VILLAS AT ASPEN TRAILS PRELIMINARY PLAN

LOCATED IN PORTION OF SECTION 9,
TOWNSHIP 15 S, RANGE 65 W, OF THE 6TH P.M.,
EL PASO COUNTY, STATE OF COLORADO

SP-23-004

PROJECT NUMBER: 0219-06
 SHEET 2 OF 8

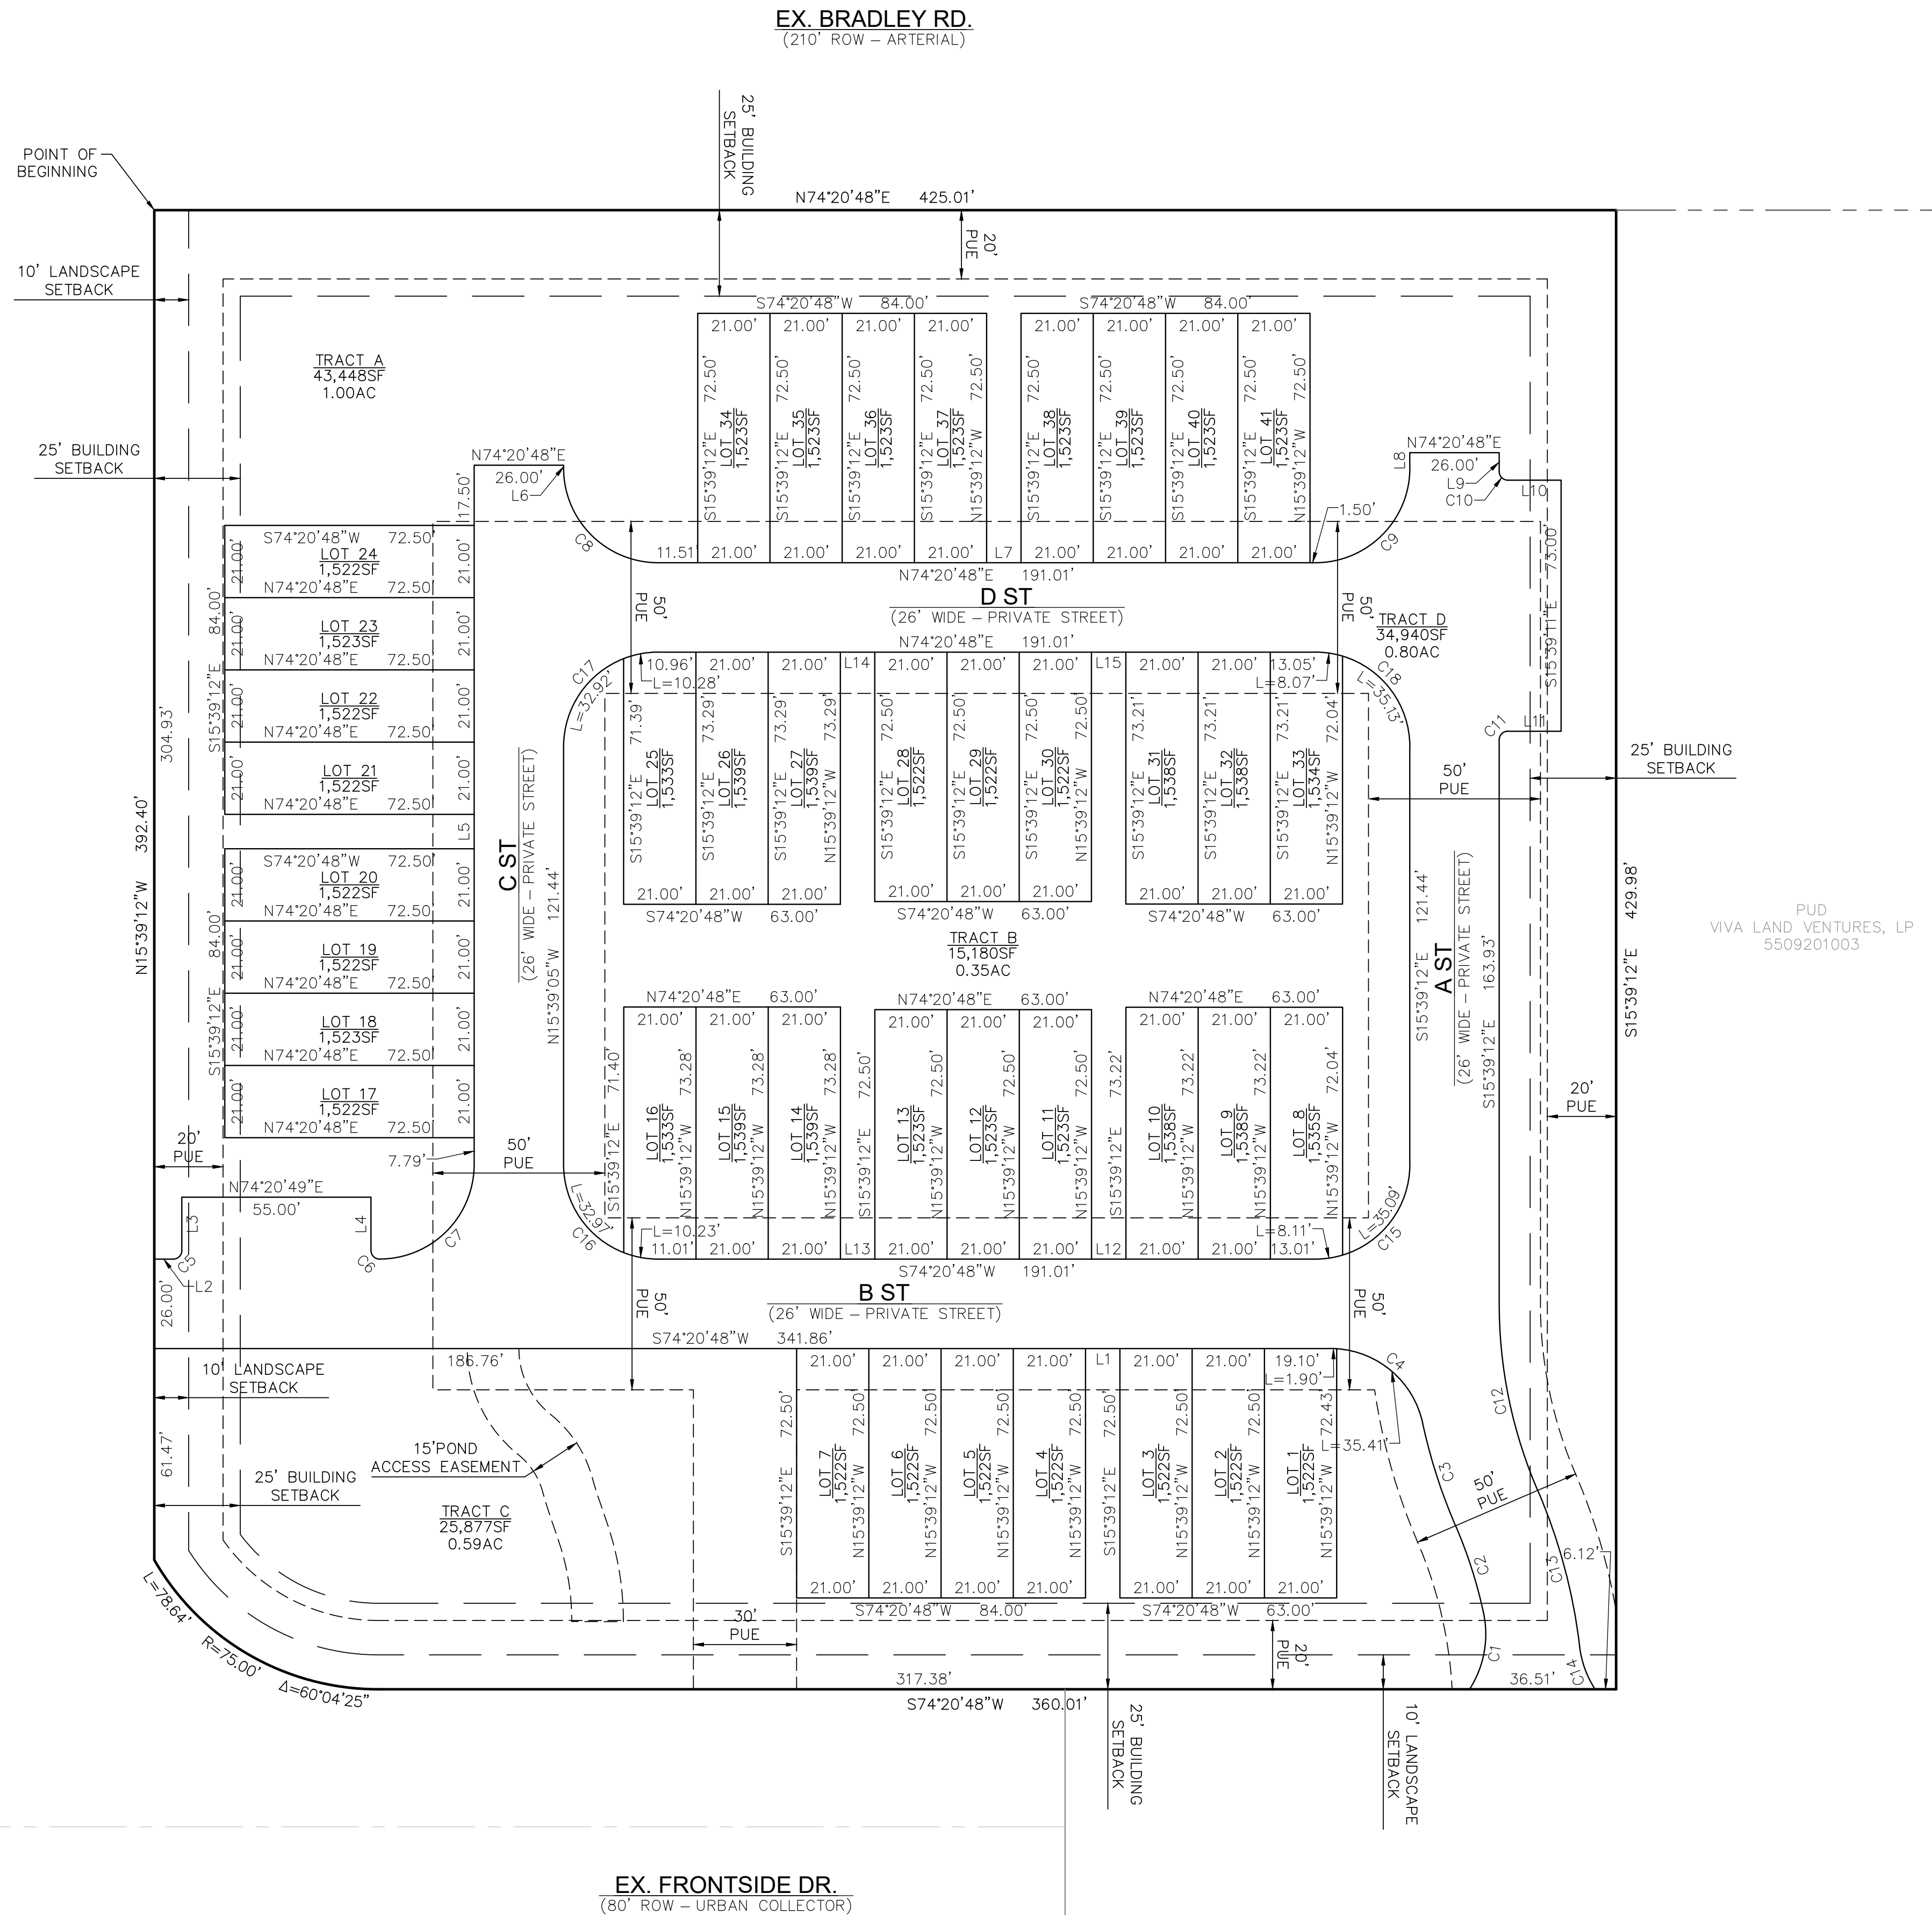
Show and label POC and POB

Label property boundary

Label all adjacent property owners

Label streets as private

Include street width

What is this line for if it's in the middle of a utility easement?

Show & label all easements

Include ROW width and roadway classification for all roads

Z:\0001-Dakota Springs\02-Waterview Partners\19-06ns Roy D S\CAD\Plans\02\19-06ns Roy D S - Prelim - Site Plan.dwg

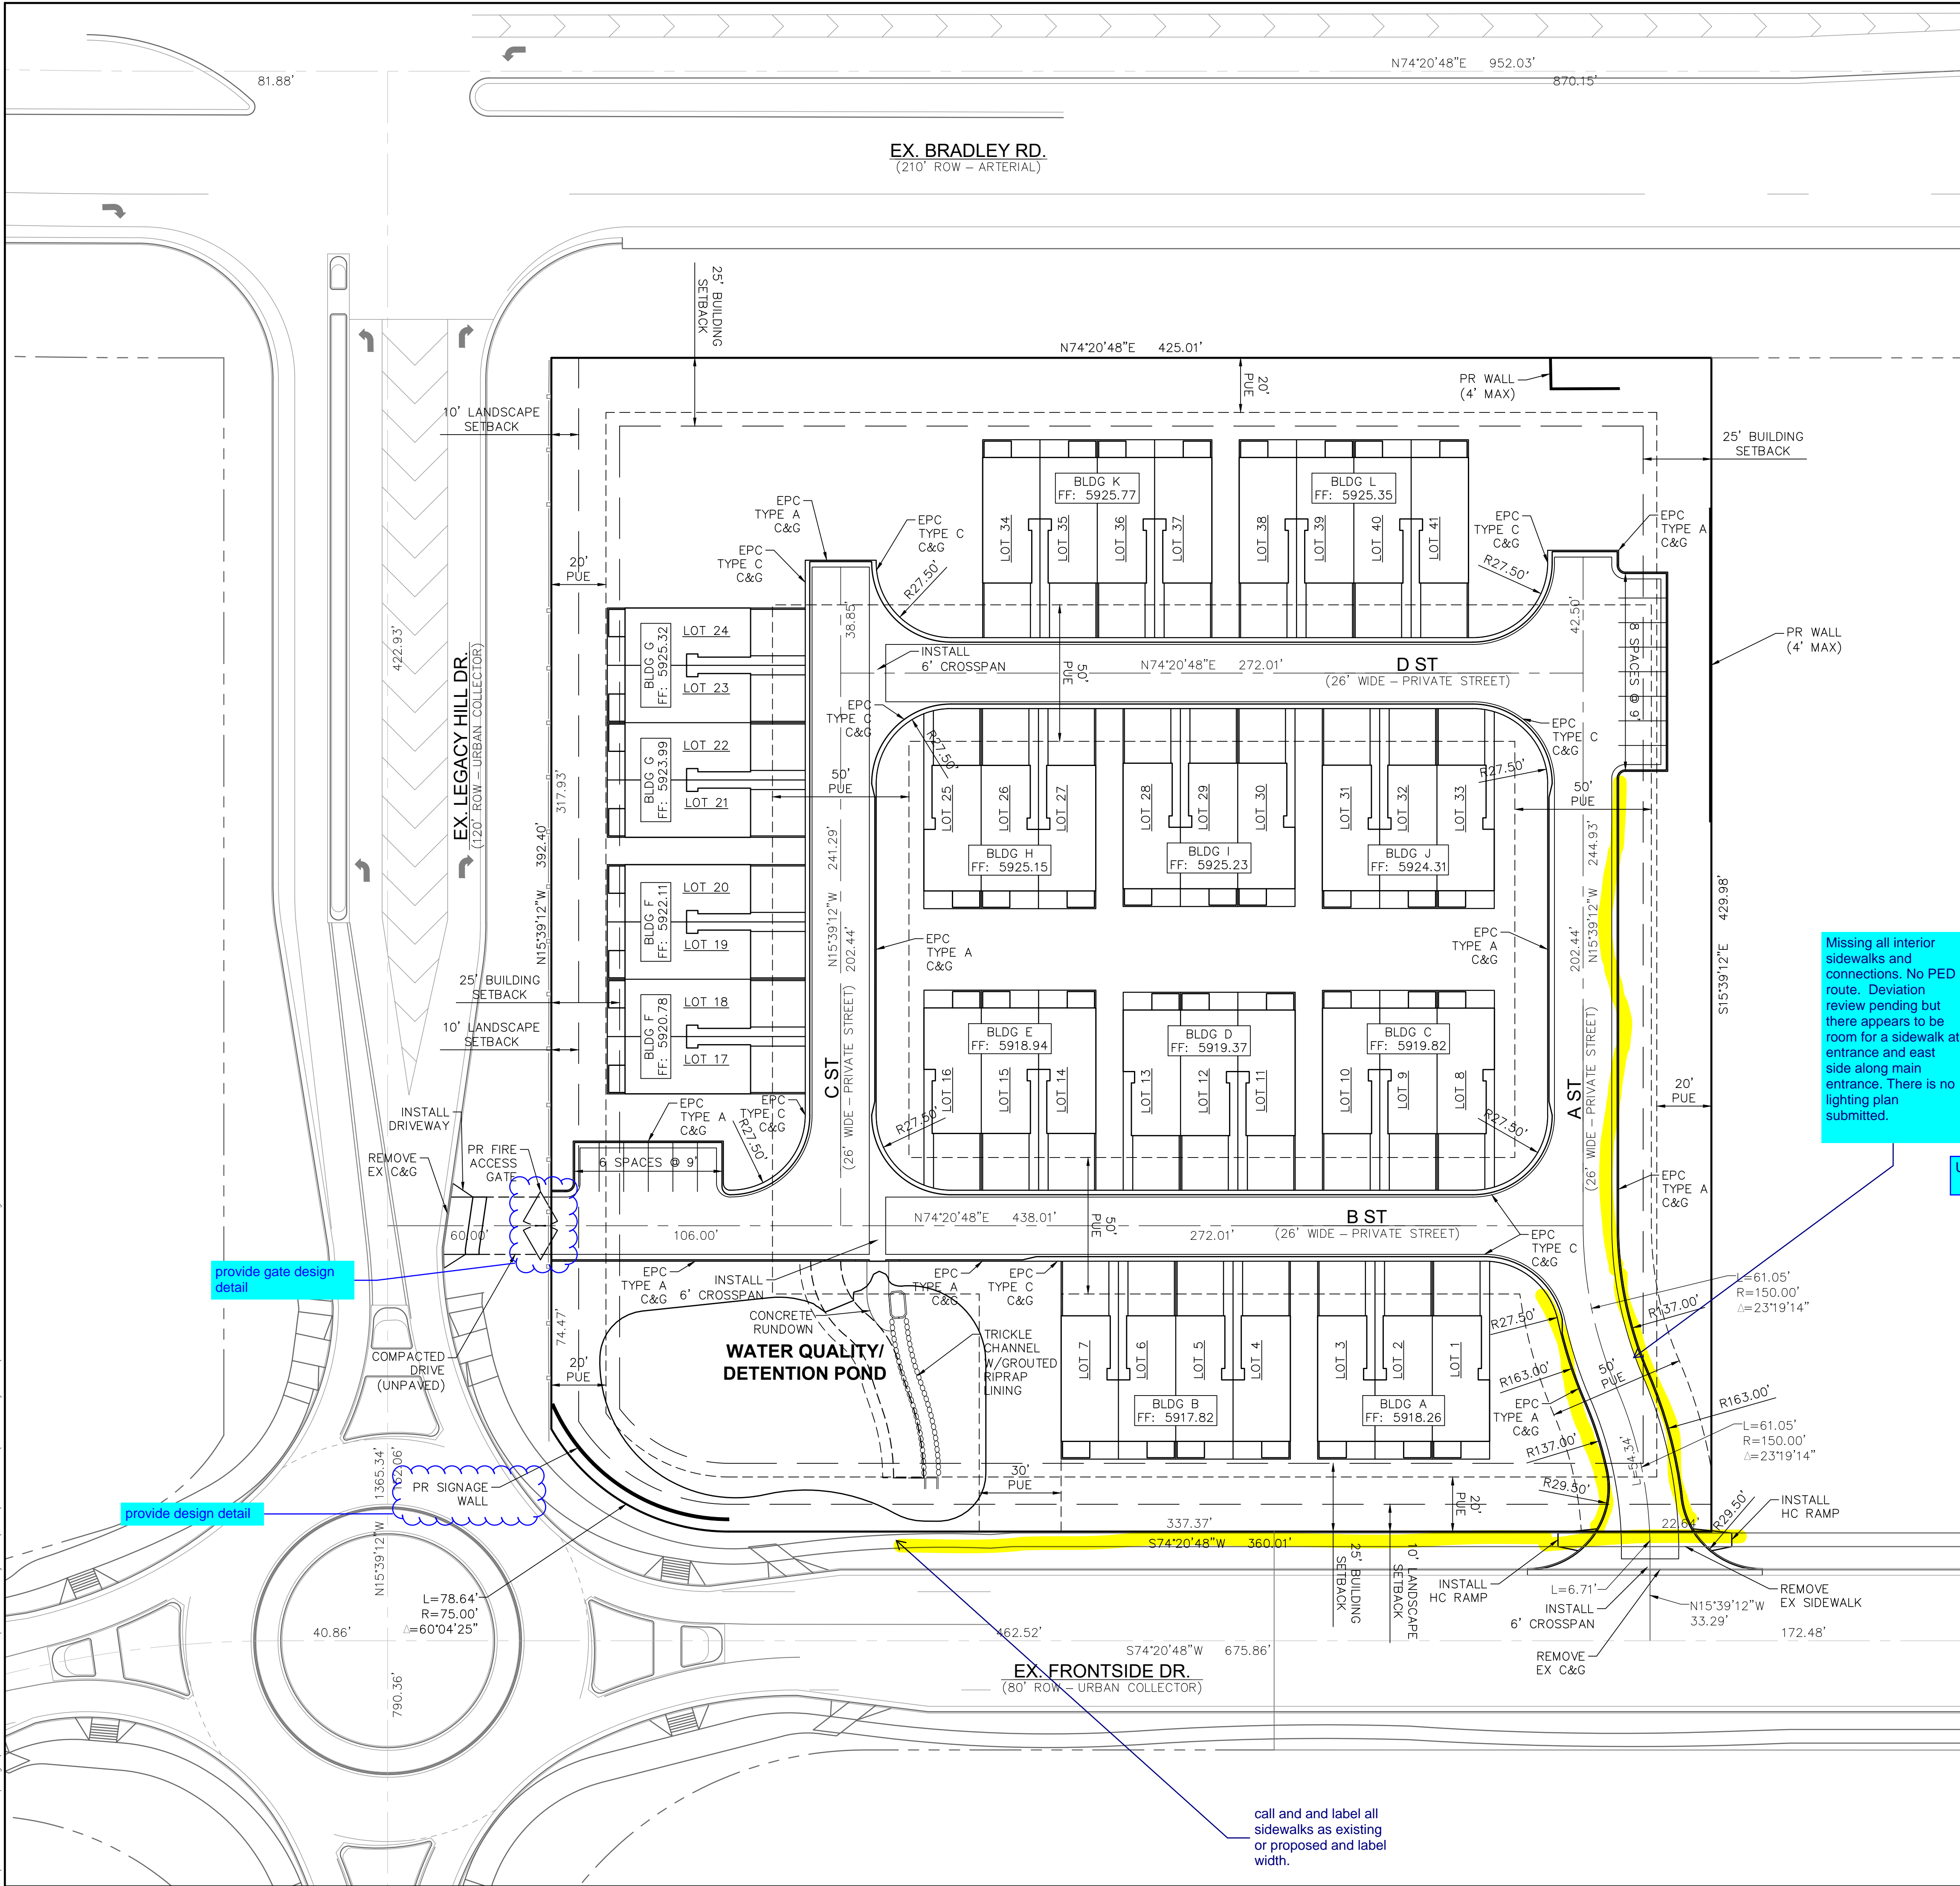
No access is allowed to Legacy Hill Drive per Trails at Aspen Ridge Filing No. 1. Secondary access will need to be obtained through property to the east. Has fire department required a secondary access?

Include cross section of roads

Turn off utilities on this sheet

Show and label all sidewalk, curb ramps, cross pans, curb type

Provide centerline information for roads.

Show and label sidewalk

PRELIMINARY PLAN
GRADING PLAN

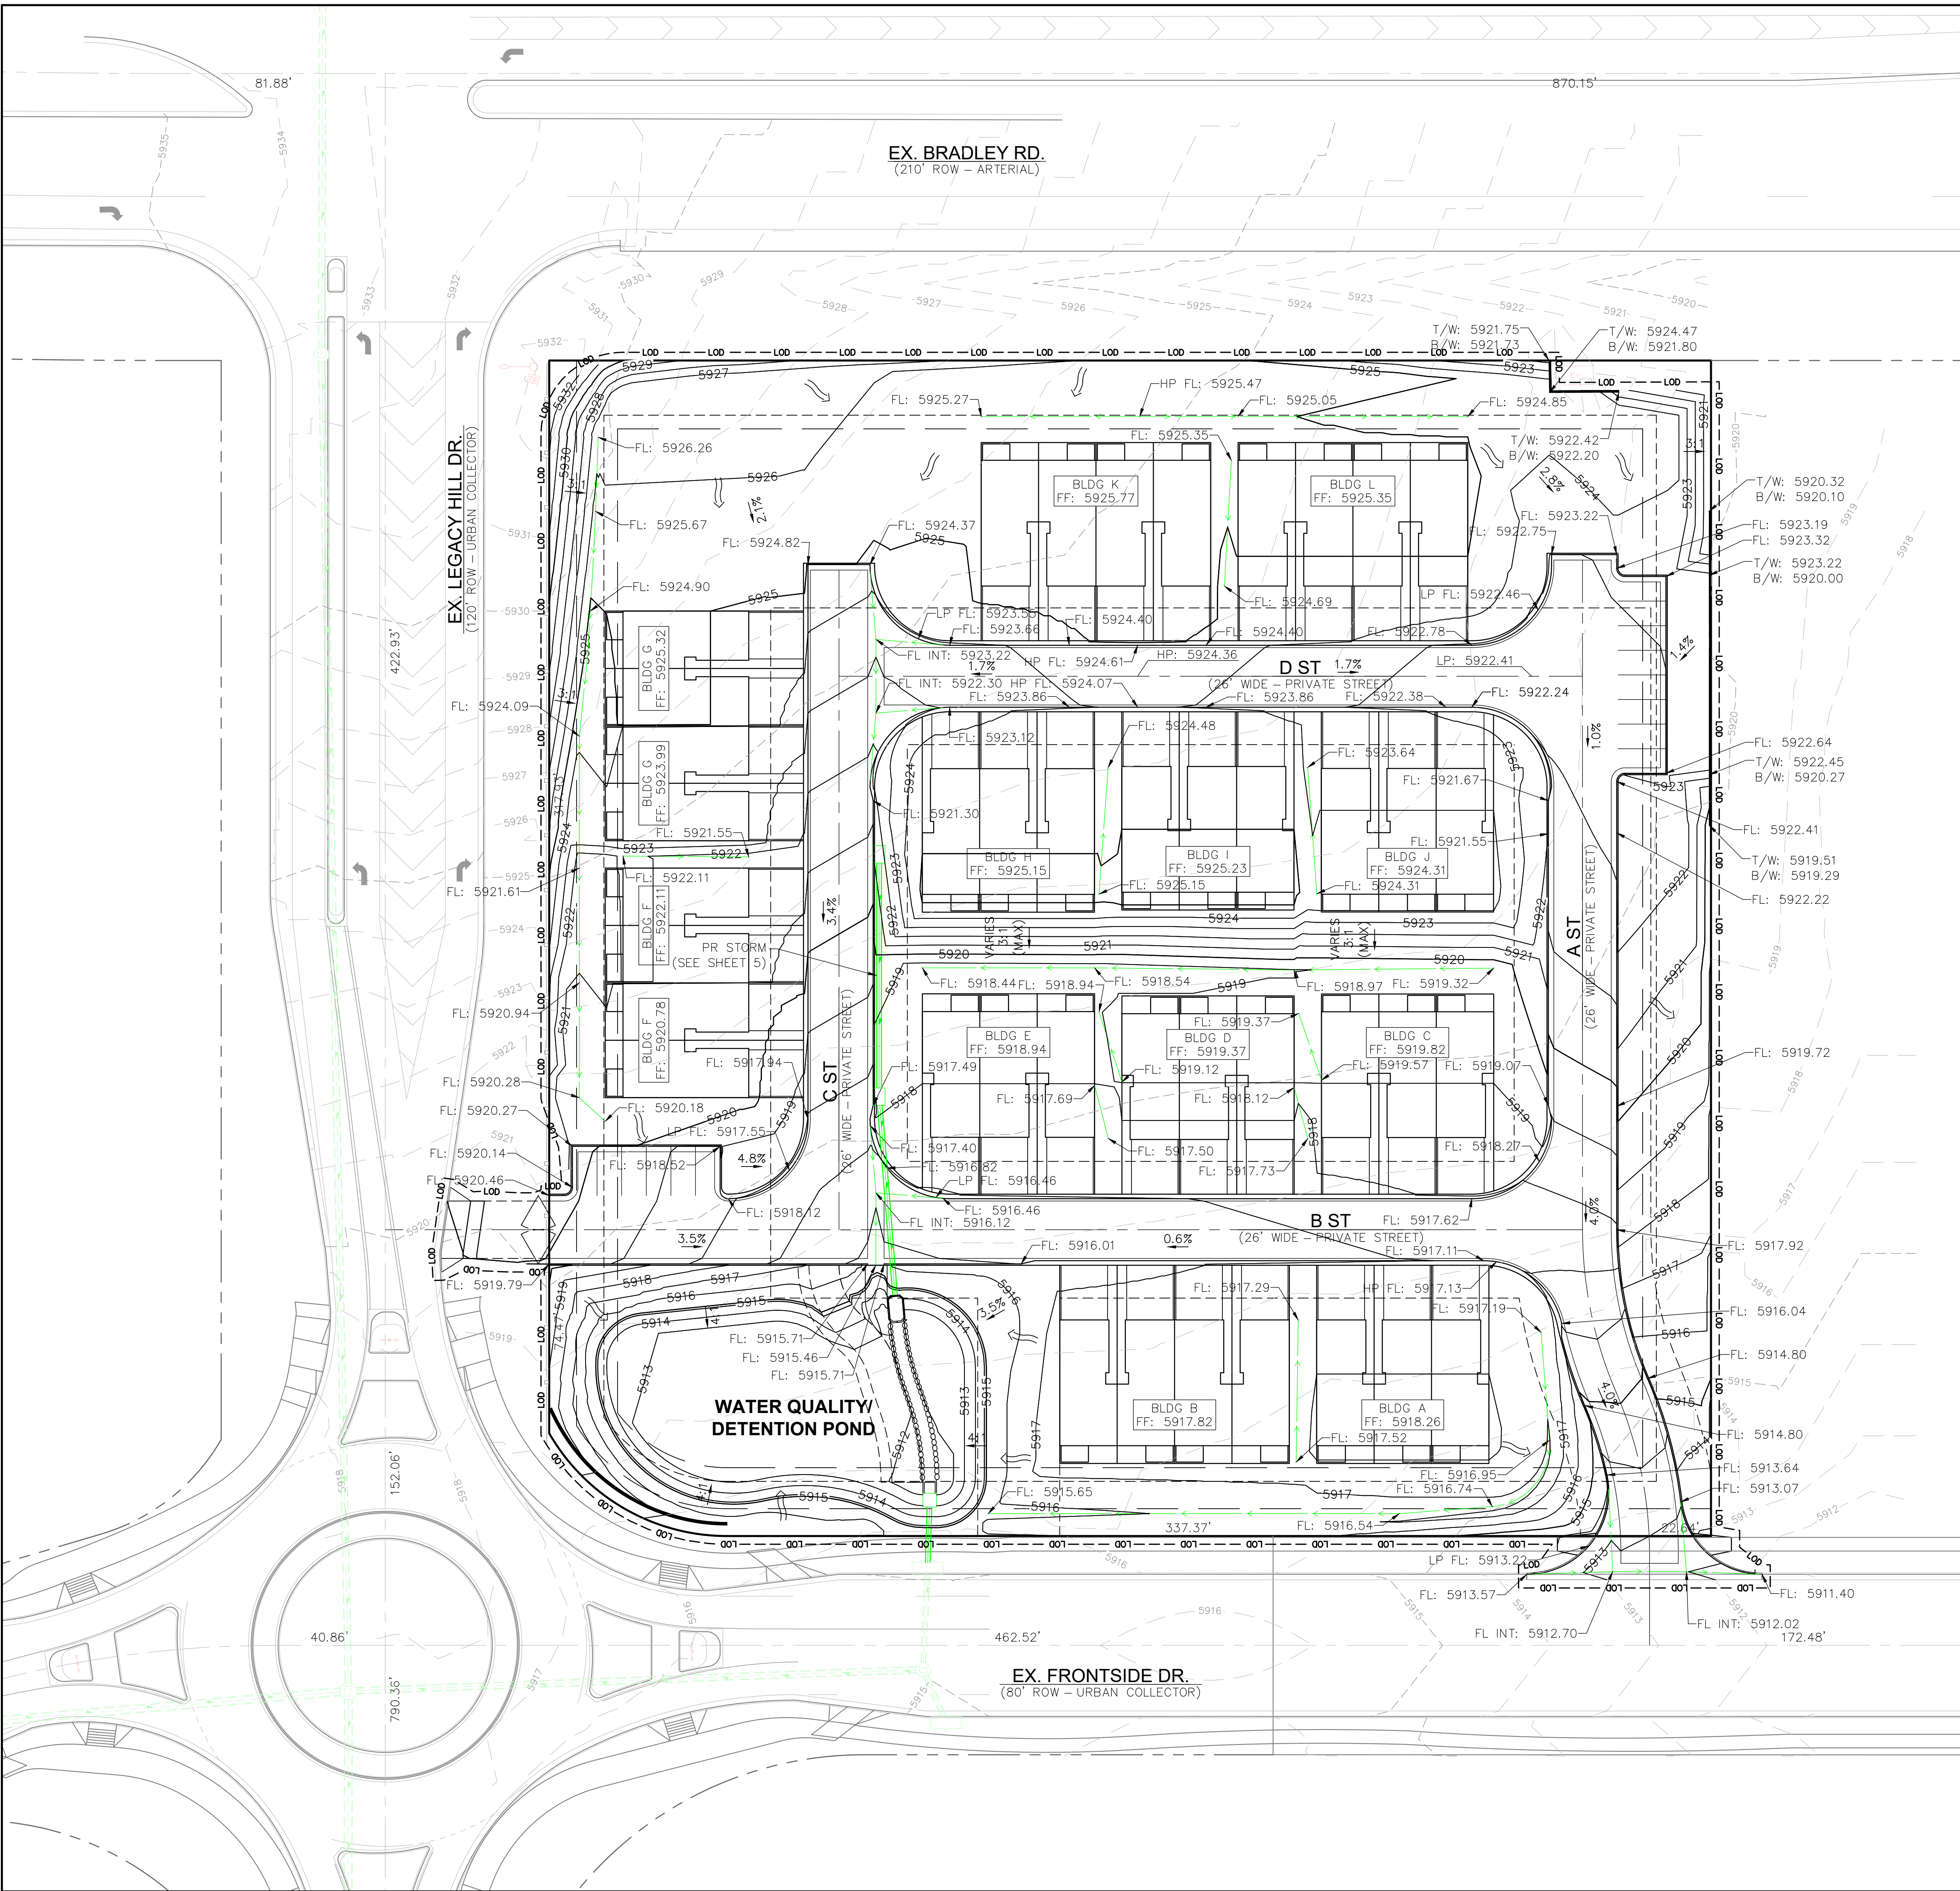
Provide legend

Turn off utilities on this sheet.

Provide centerline grades for all roads

Provide slopes
